Office of  
Environment  
& Heritage

DOC18/249153  
SSD 8740

**Exhibition of Schofields Public School redevelopment, 60 St Albans Road, Schofields (SSD 8740)**

## **Attachment 1 – Office of Environment and Heritage (OEH) comments redevelopment of Schofields Public School 60 St Albans Road, Schofields (SSD 8740)**

Figure 12 | Proposed Landscape Plan (Base source: Applicant's Modification Application 2019)

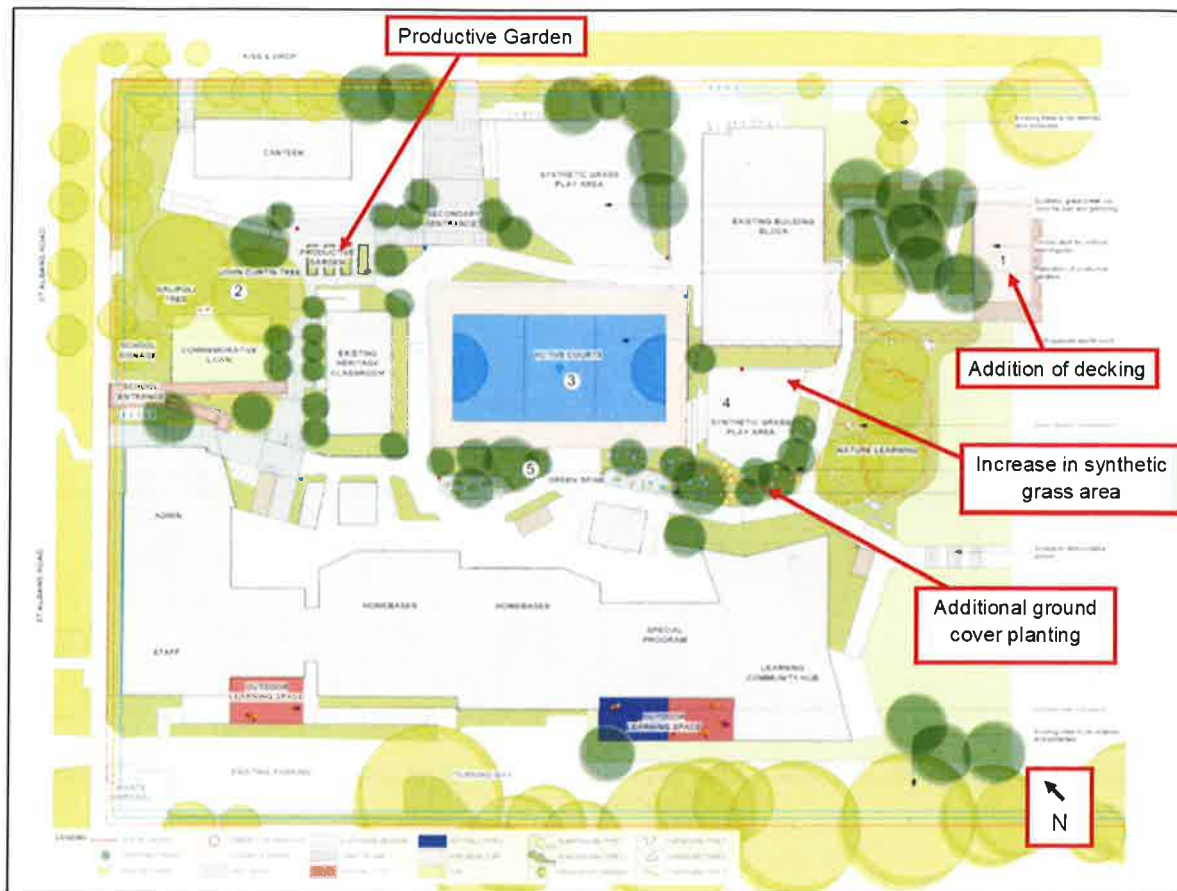
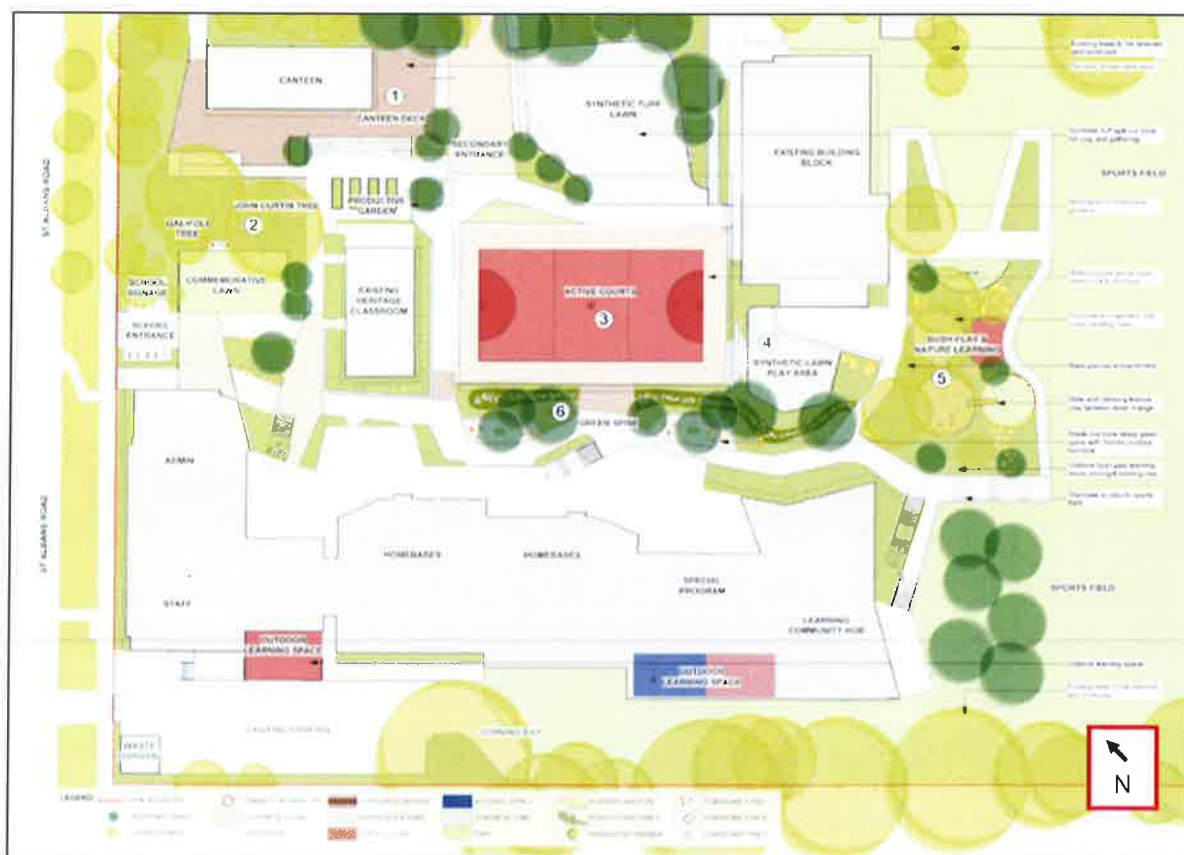
Please note that most of the proposed species listed on the indicative planting schedule landscape plan are inappropriate. The indicative planting schedule contains some cultivars and exotic species. Only local provenance species and no exotic species, should be used. The following documents should be used to develop a revised species list:

While a range of species occurs in Shale Plains Woodland, preference should be given to the positive diagnostic species listed in the above-mentioned documents. Further, the following species listed on the indicative planting schedule do not form part of Shale Plains Woodland and should not be used:

- *Banksia integrifolia*
- *Banksia spinulosa*
- *Banksia spinulosa*
- *Callistemon linearifolius*
- *Carex appressa*
- *Casuarina glauca*
- *Dianella caerulea*
- *Grevillea* Bronze Rambler
- *Grevillea* Royal Mantle
- *Grevillea poorinda* Royal Mantle
- *Hakea sericea*
- *Kunzea ambigua*
- *Liriope muscari* Evergreen Giant
- *Lomandra longifolia* Tanika
- *Lomandra longifolia* Verday
- *Melaleuca linariifolia*
- *Melaleuca nodosa*
- *Syzygium smithii* (now called *Acmena smithii*)
- *Trachelospermum jasminoides*
- *Viola hederacea*
- *Westringia fruticosa* Grey Box

- Tozer et al. (2010) Native vegetation of southeast NSW: a revised classification and map for the coast and eastern tablelands. *Cunninghamia* 11(3): 359 – 406.
- Tozer (2003) The native vegetation of the Cumberland Plain, western Sydney: systematic classification and field identification of communities. *Cunninghamia* 8(1): 1 – 75.
- OEH (2013) The Native Vegetation of the Sydney Metropolitan Area. Volume 1: Technical Report. Version 2.0. Office of Environment and Heritage, Department of Premier and Cabinet, Sydney and
- OEH (2013) The Native Vegetation of the Sydney Metropolitan Area. Volume 2: Vegetation Community Profiles. Version 2.0. NSW Office of Environment and Heritage, Sydney.
